Project Name / File No.: Brodie / PA22-023
Applicant: JM1 Holdings, LLC
Project Description: 45 Lot PRD-Subdivision
Re: Response to 2nd Review Comments

This letter serves as the Applicant's formal response to the 2nd review comments received on December 21st, 2022 to our recent application materials submitted to the City of Marysville. To ensure that each of the comments have been responded to, we have incorporated each of the City's comments along with the Applicant's response to each below.

DRAWING NO.:	IL-02
SHEET NO.:	2
OF	3
SHEETS

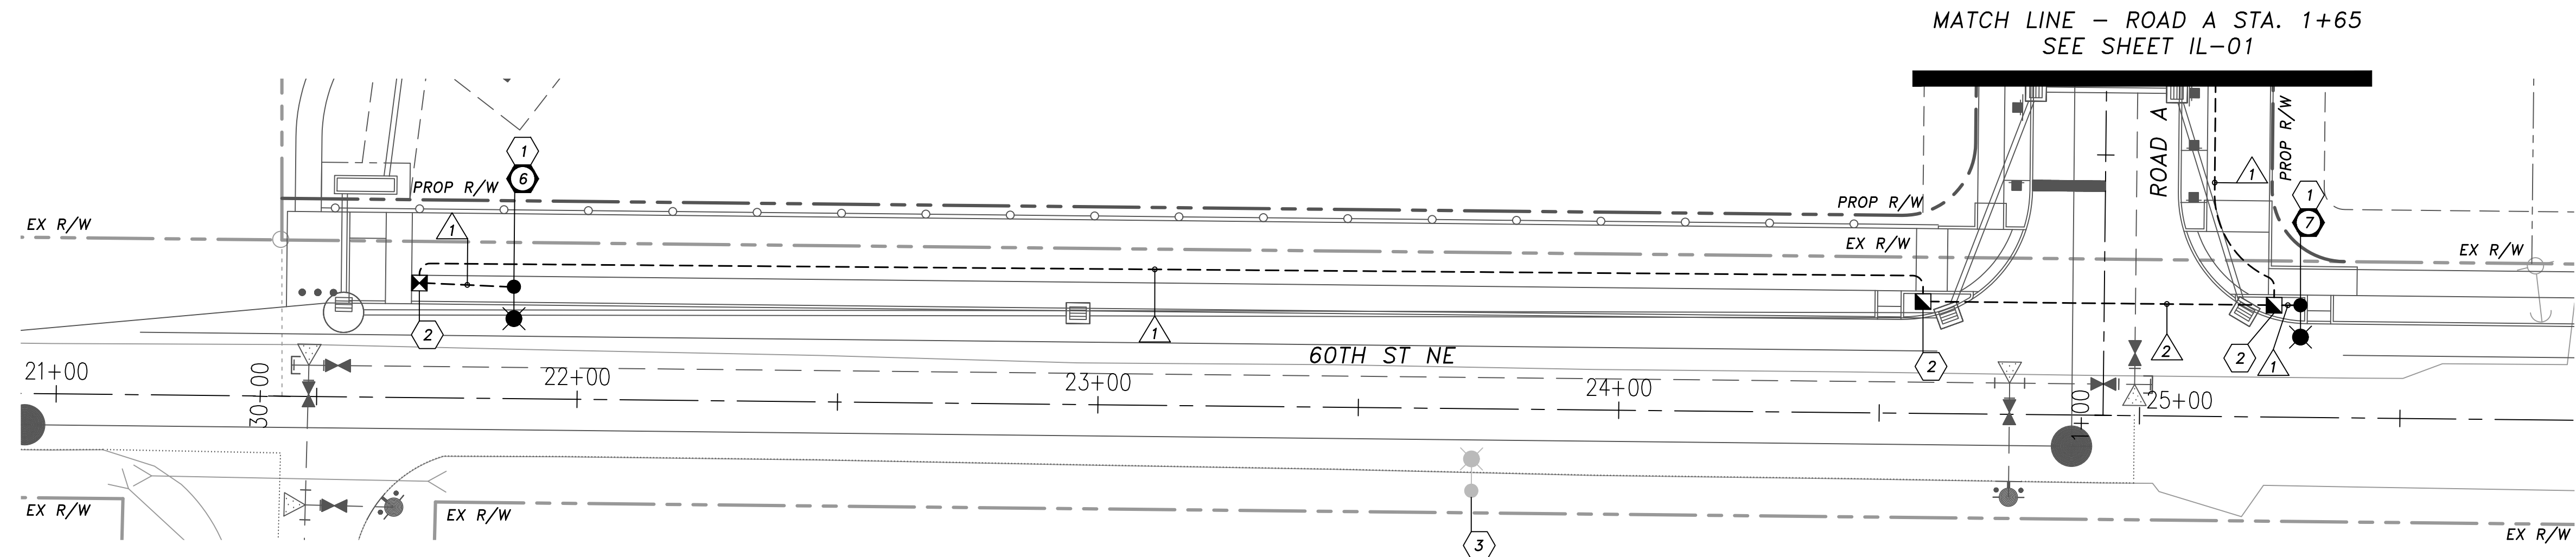
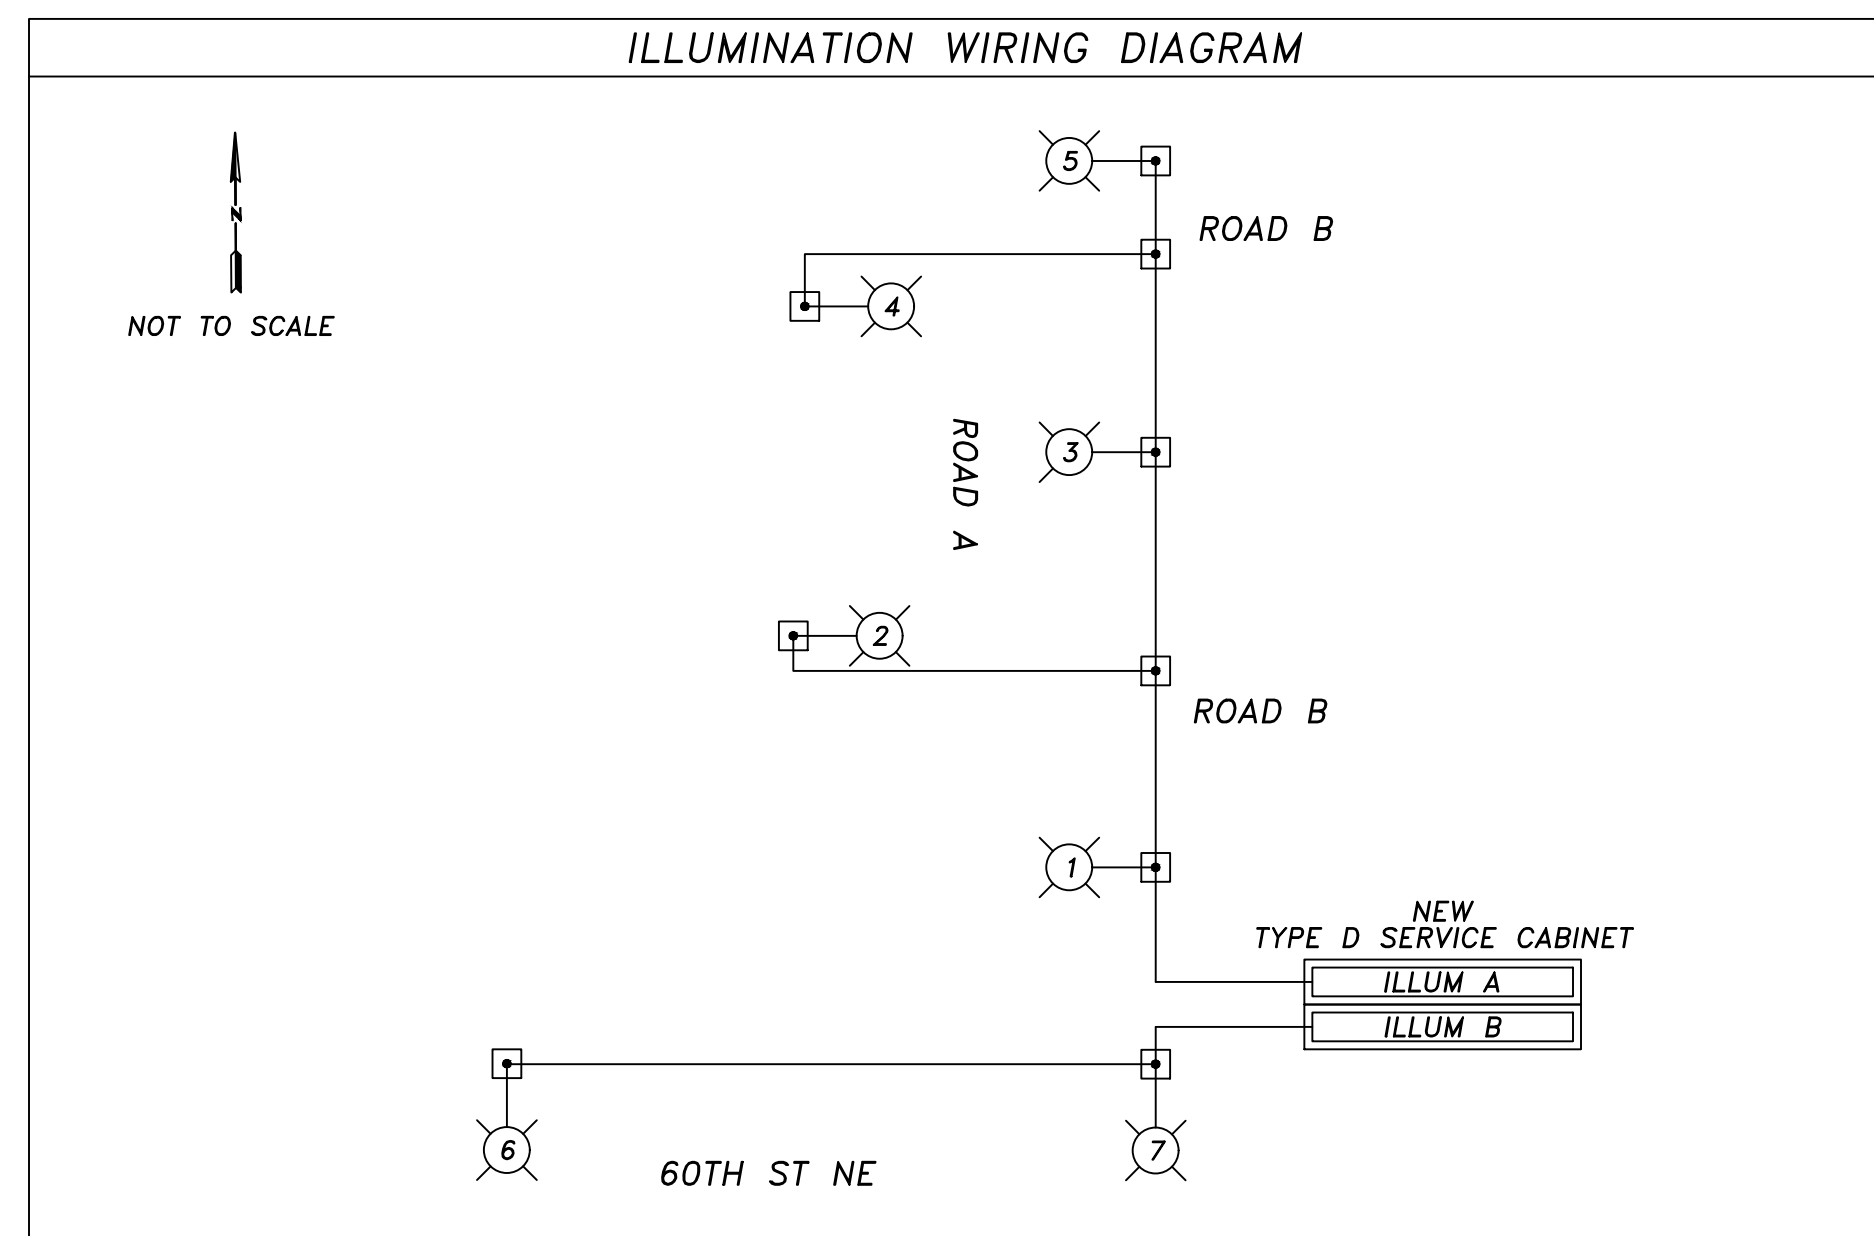
- 2) Per EDDS 3-506, street lighting will be required as part of civil construction plans.
 - a. Street Lighting upon 87th Ave NE from Soper Hill RD to 64th ST NE (SR 528) shall including City owned decorative street lighting to match installations within the vicinity.

1. Approximate Street Light locations upon Road B:
 - a. STA 10+75
 - b. STA 12+75
 - c. STA 14+75
 - d. STA 16+75
Applicant's Response: Acknowledged. Applicant is working with PUD on design.
